Your Ref: OWPC17901
Our Ref: EP/26/18/HH 01-03-2018
Please ask for:
Mrs A Gardner

Loft conversion with two dormers, plus replacement conservatory roof.

5 The Plantation East Preston

Thank you for your internet representation made on 12th April 2018 which has been recorded as '**an objection**' with the comments as follows:

Job Title	5 THE PLANTATION, EAST PRESTON	Item	PROPOSED EAST & WEST ELEVATIONS
Designed by		Job No.	
Date		Sheet	FR.05
Checked by		Rev.

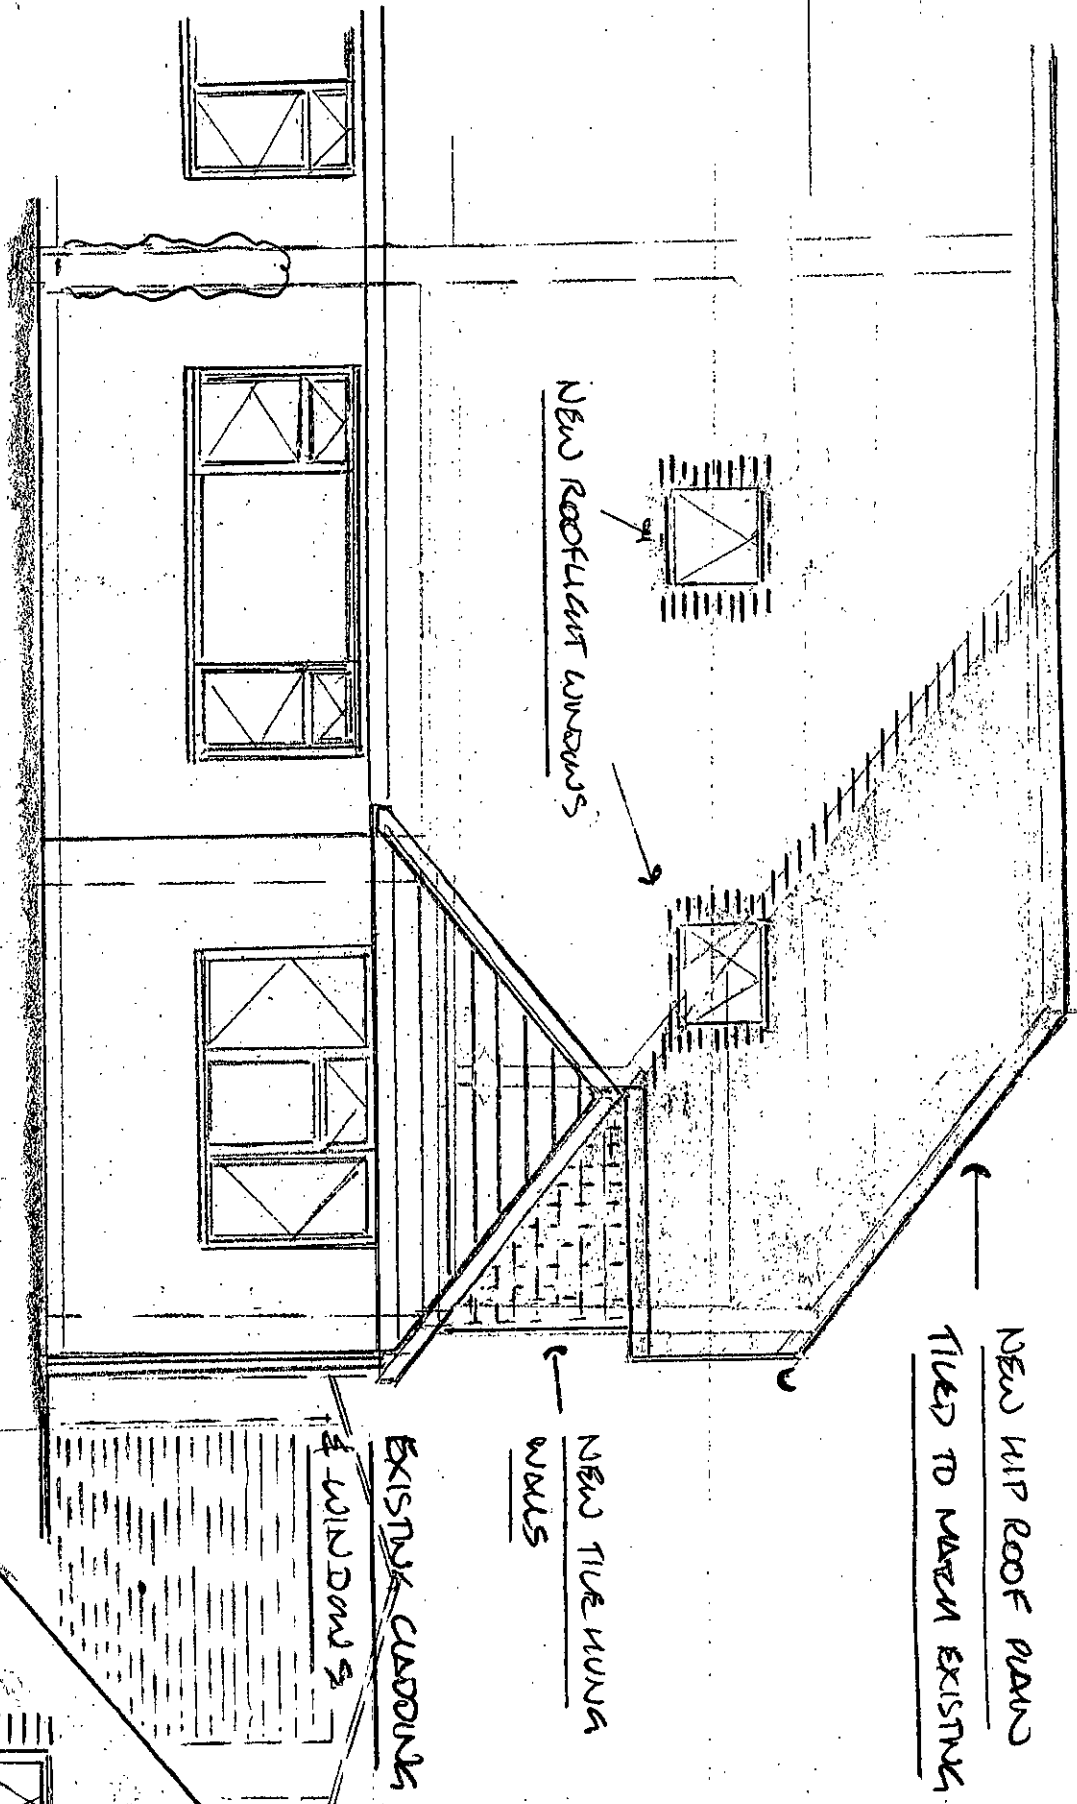
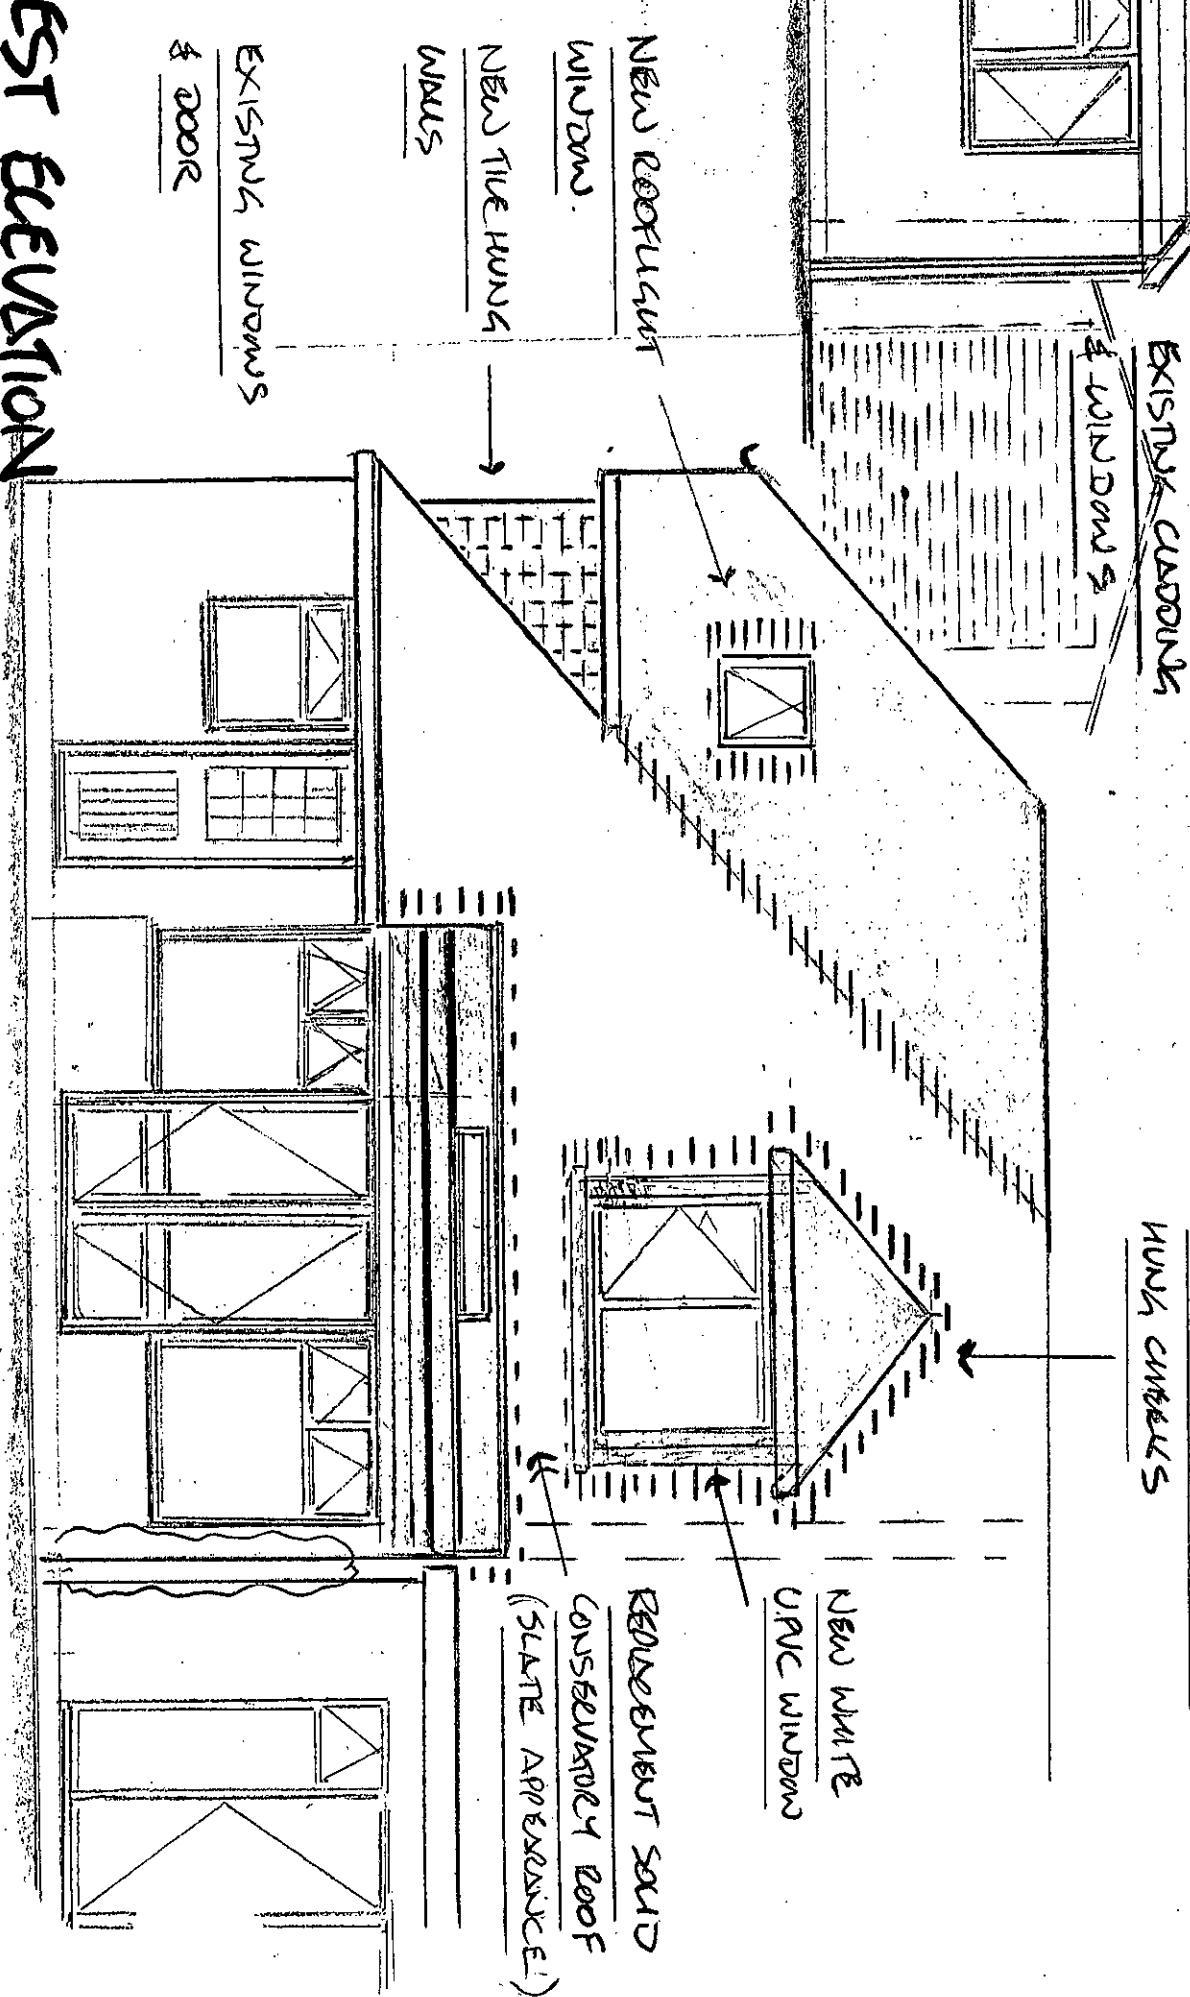
The bungalow which is the subject of this application is the northern half of a pair of semi-detached bungalows. The proposed alterations to this bungalow would convert it into a chalet, with a new tile hung wall 1.5 storeys high on the north side, the ridge of the roof extended towards the north side, and a hipped end to this roof. The resulting building would be unlike the southern half of the pair of bungalows. The resulting building would therefore be unbalanced, with the northern half larger than the southern half. The addition to the northern half would also transform the appearance of this bungalow.

The addition would not sympathetically relate to and is not visually integrated with the existing building in design, form and scale; and it would not be visually subservient to the existing building. It would therefore be contrary to Policy DEV19 of the Arun Local Plan.

Job Title	5 THE PLANTATION, EAST PRESTON			Item	PROPOSED ROOF PLAN & SECTIONS	
Designed by	Date	Checked by	Job No.	Sheet	FP.07	Rev.

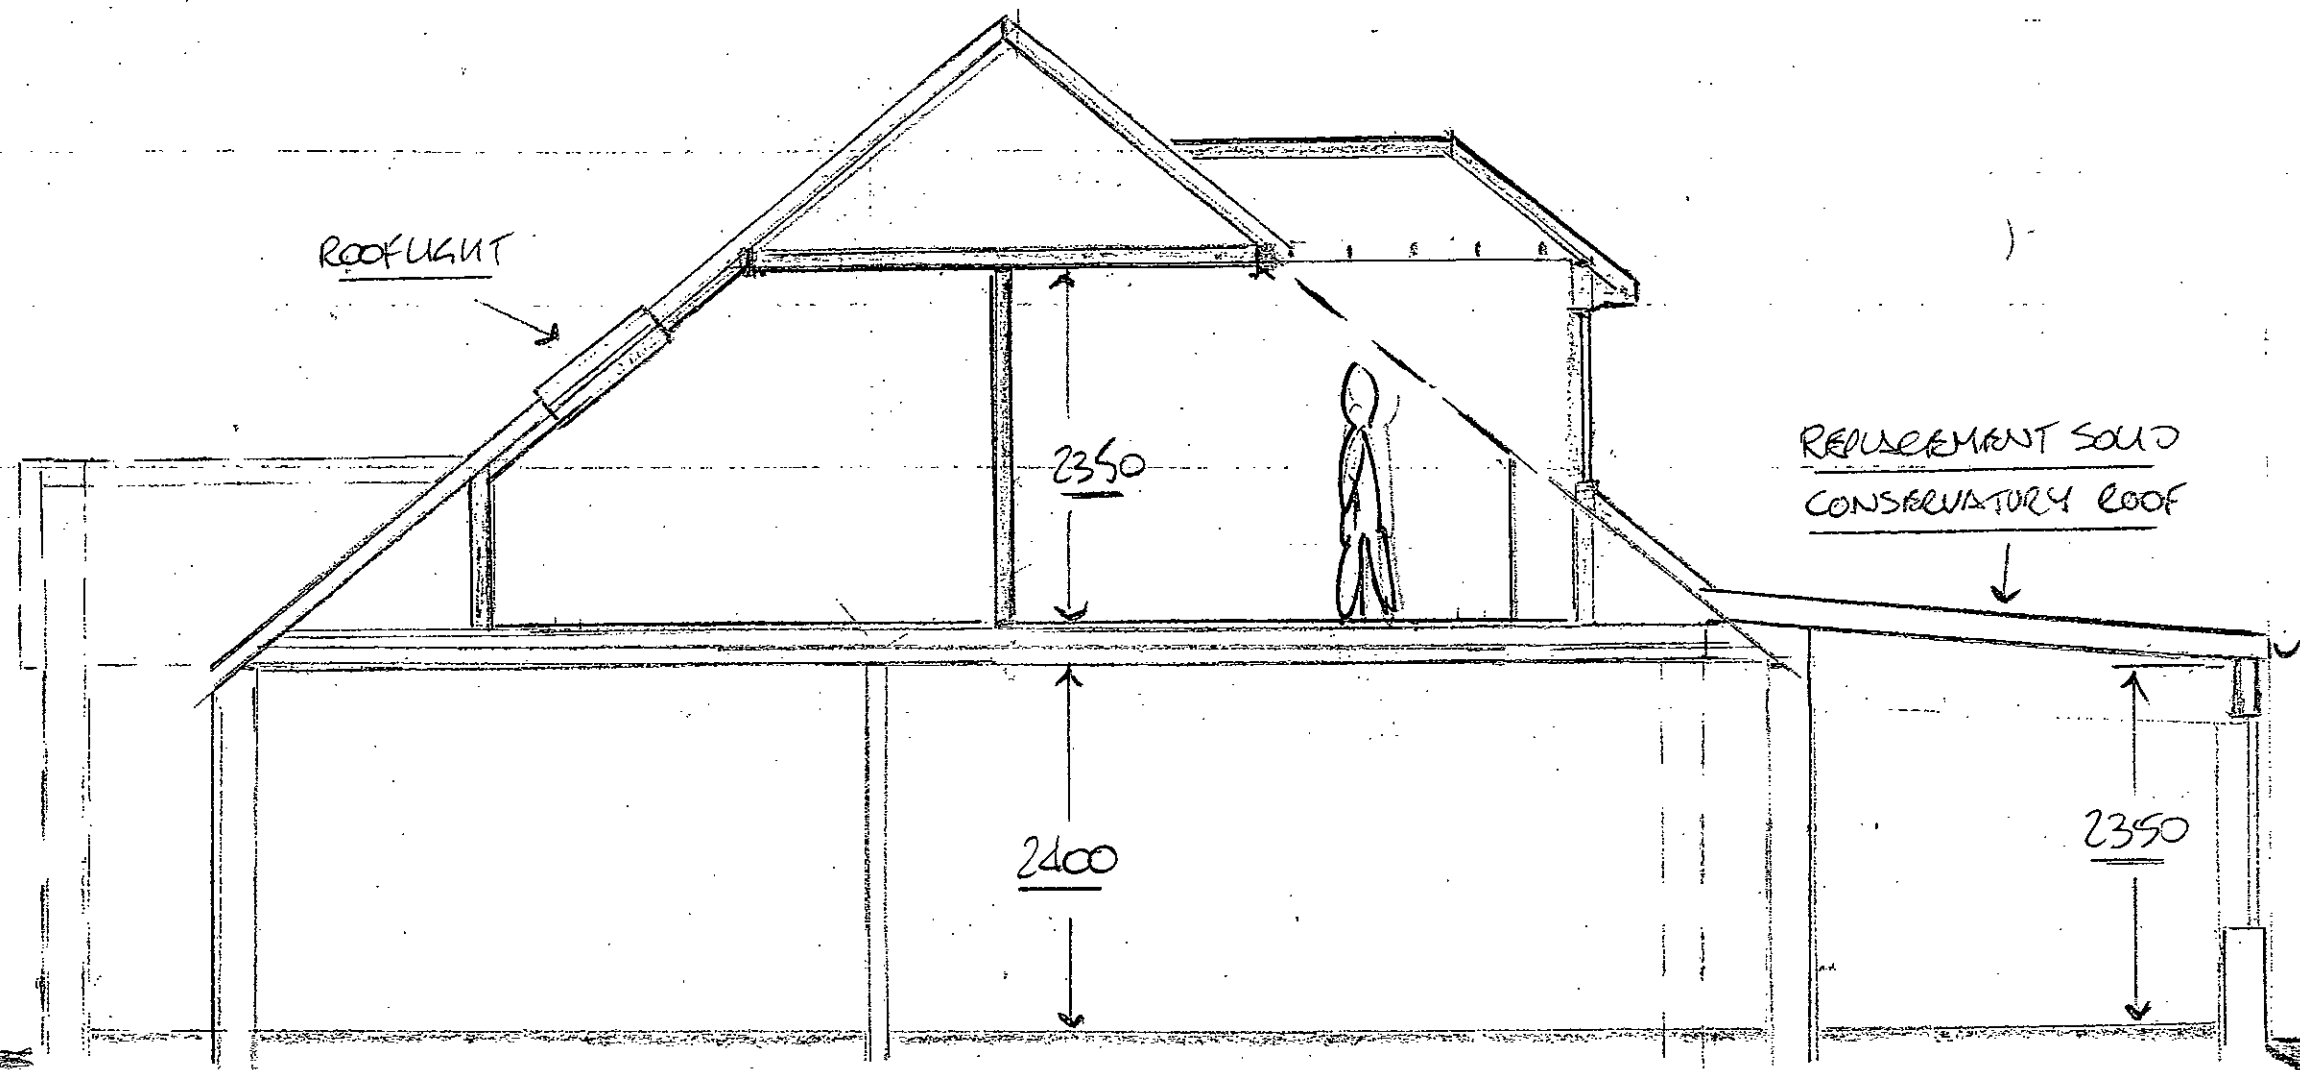
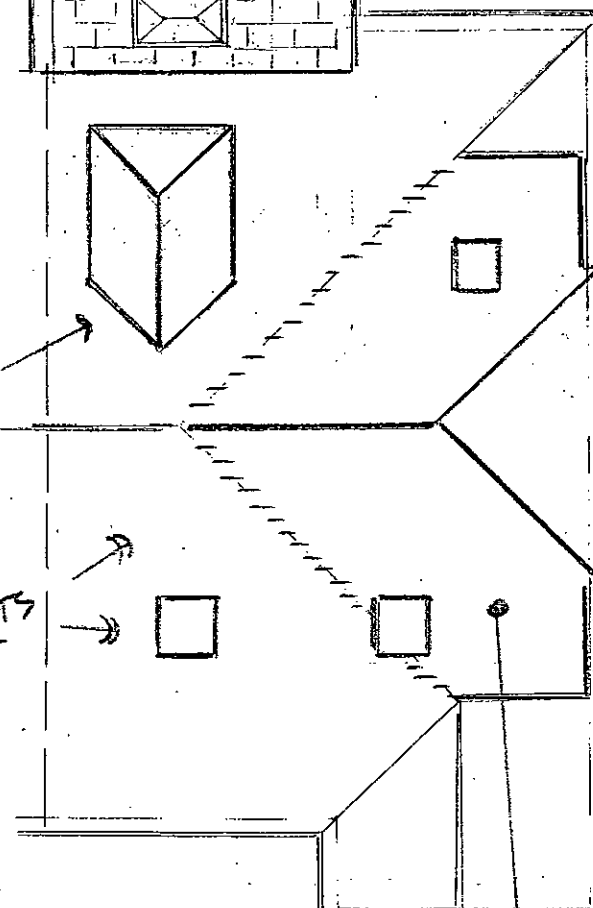
The addition would not look as if it is part of the original design of the house; the resulting building would be unbalanced; and it would not harmonise with other buildings in the road in scale or design. The other buildings are all bungalows. The alterations would therefore conflict with Policy 1 of the East Preston Neighbourhood Plan, especially paragraph 4.16.
